From: Laura Gibbons
Sent: 14 June 2019 12:56
To: 'Kerry Simmons'
Cc: Juan Baeza
Subject: RE: Response To Application Number CM/13/19/RES at Mistletoe Farm Horsemere Green Lane

'Inadequate information has been submitted to demonstrate that the site can be sufficiently drained in accordance with Q SP1 of the Arun Local Plan and Section 14 of the National Planning Policy Framework. As the application is to approve the layout of the site there is a risk that the proposals would not be able to be implemented.'

Drawing Title				
Engineering Details Drainage Strategy (with Ditch)				
Drawn	Checked	Scales	Paper Size	Date
KN		1:250	A1	07.19
Job No.	Drawing No.	Revision		
ES1820	602-04	C

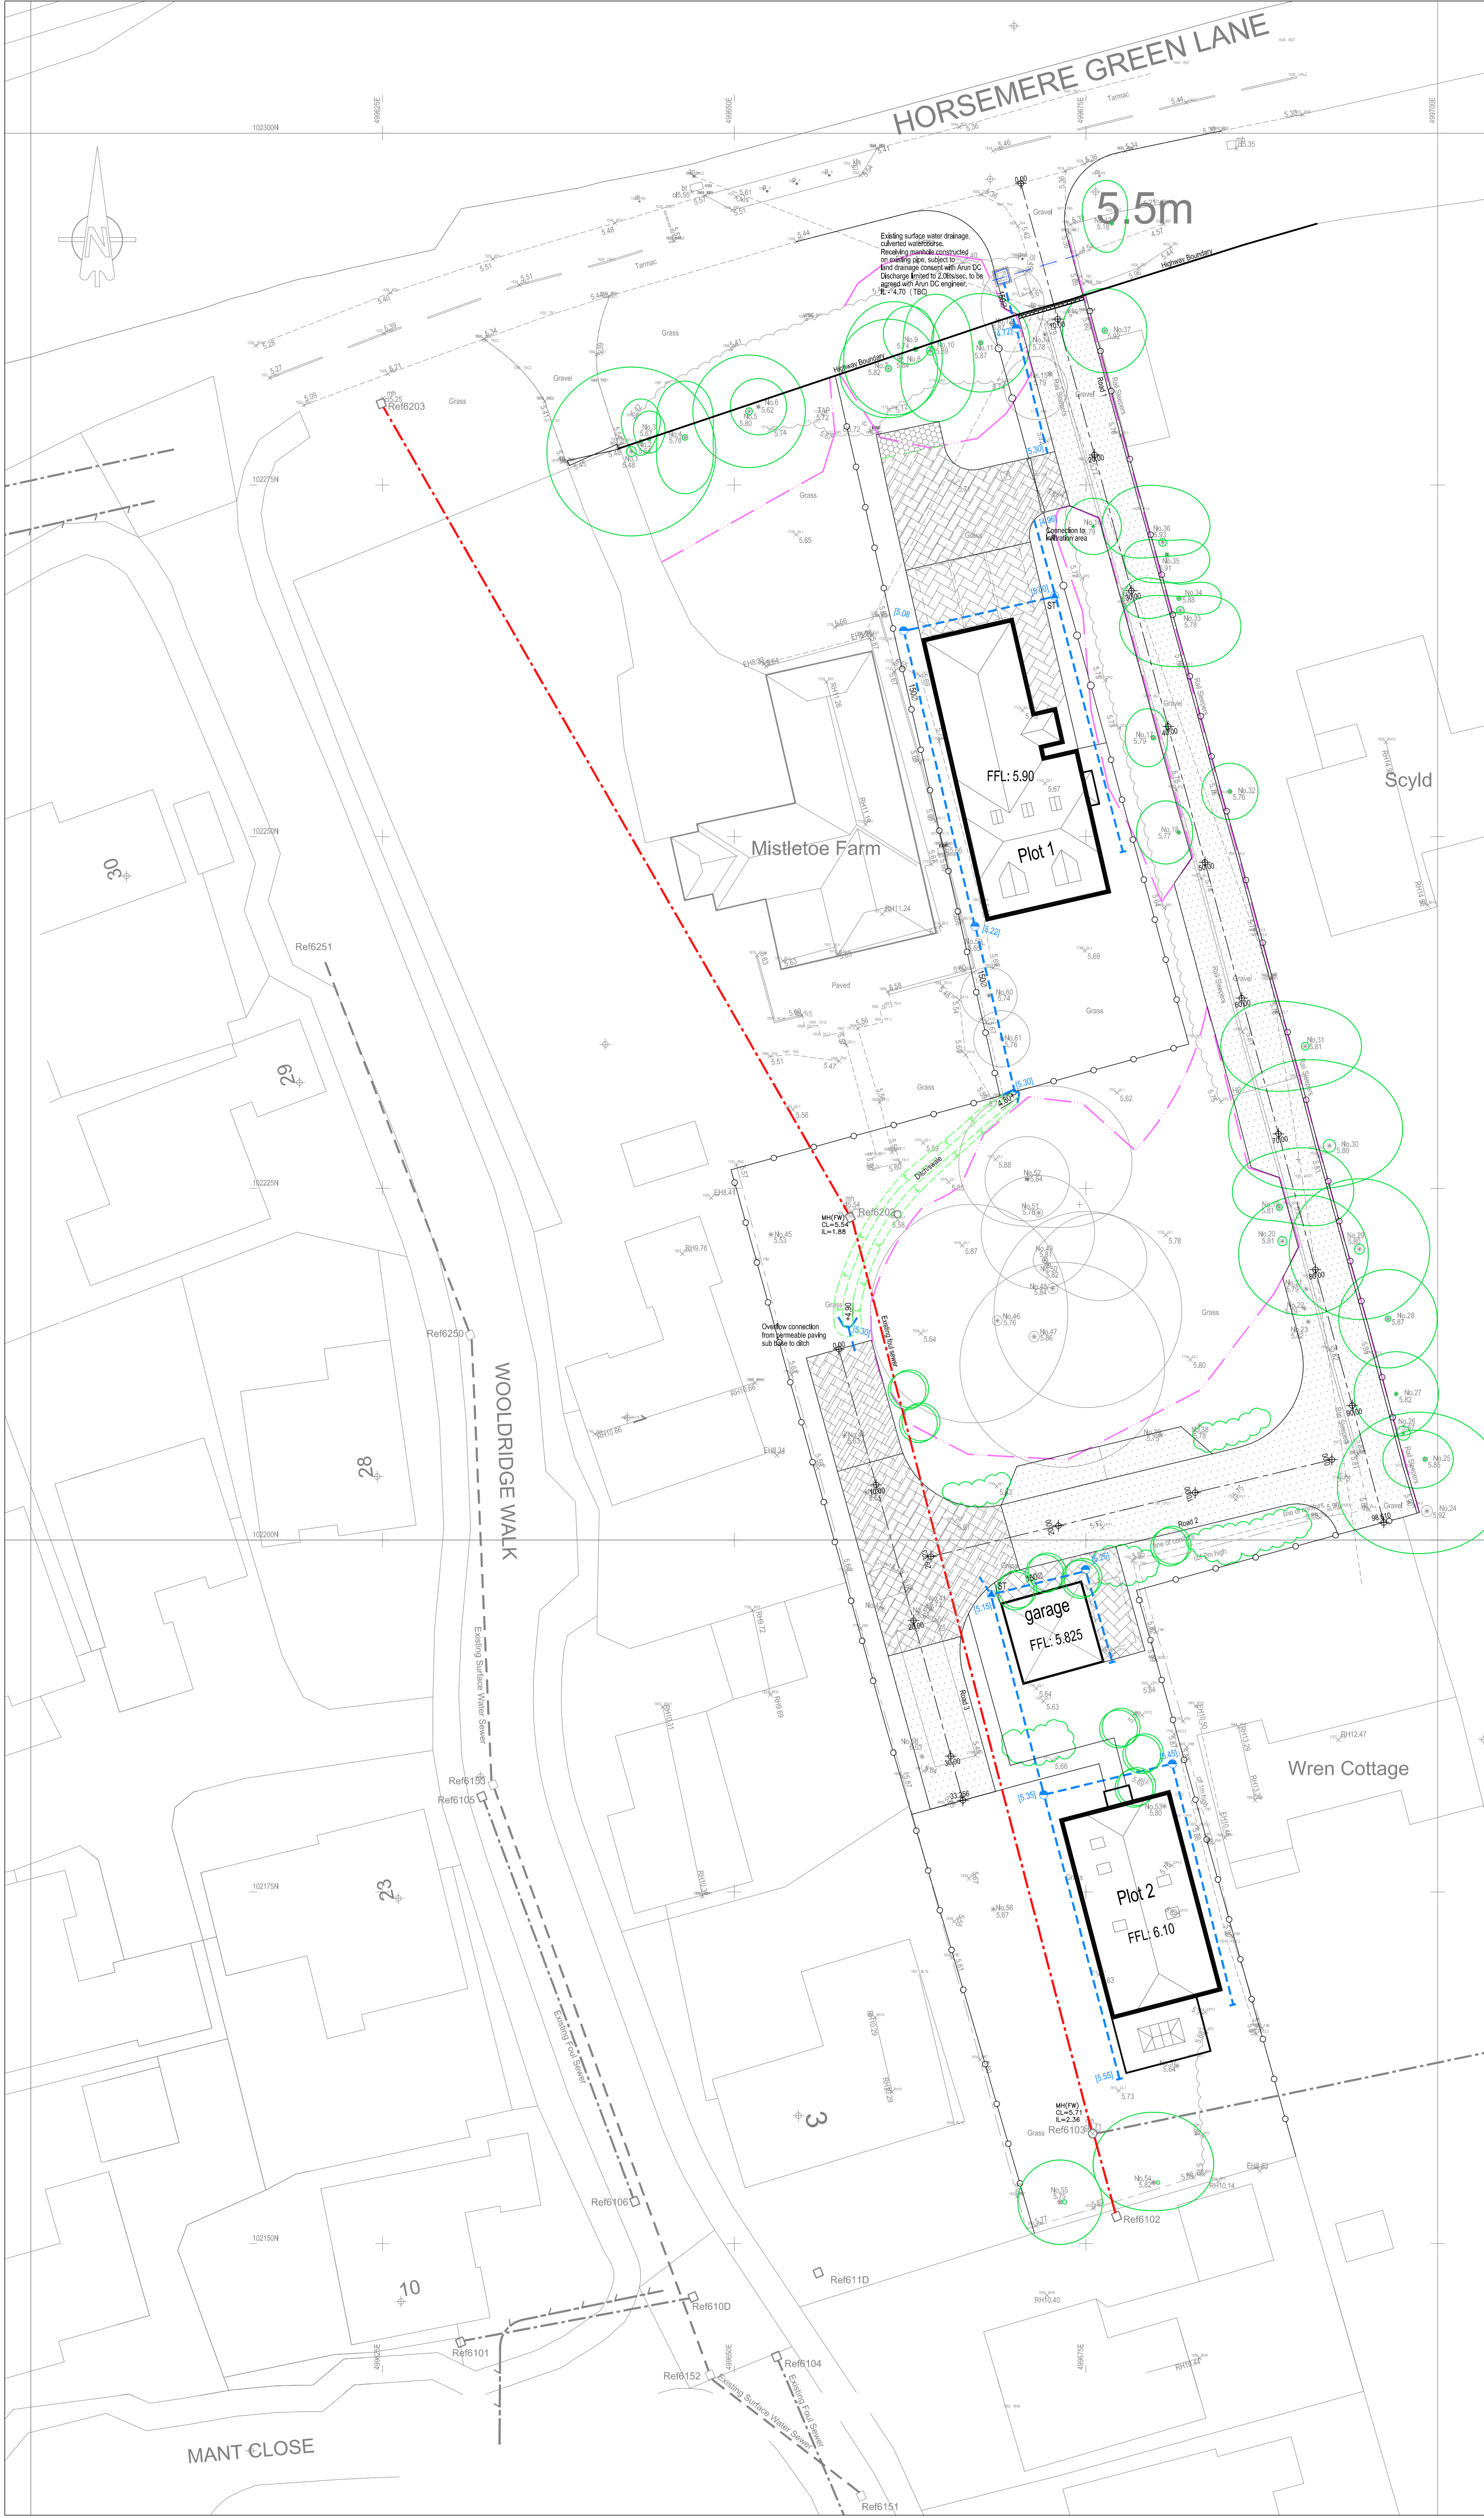
A drainage engineer cannot confirm the size of the soakaways required without the infiltration results. The soil in the area is likely to be cohesive and have low permeability, it could be that in this instance, the soil is so cohesive that infiltration is not achievable.

"As discussed there is inadequate information provided to demonstrate that the site can be drained. To support the proposed locations of soakaways I require infiltration testing results to be submitted. As stated previously even if infiltration testing is completed now this will at least indicate if infiltration is feasible and soakaways provisionally sized. Further drainage design can then be conditioned to enable winter testing and detailed design to be completed."

Before agreeing a layout, it needs to be established that surface water drainage is achievable. The Engineers are currently unconvinced that the layout provides sufficient space for surface water drainage.
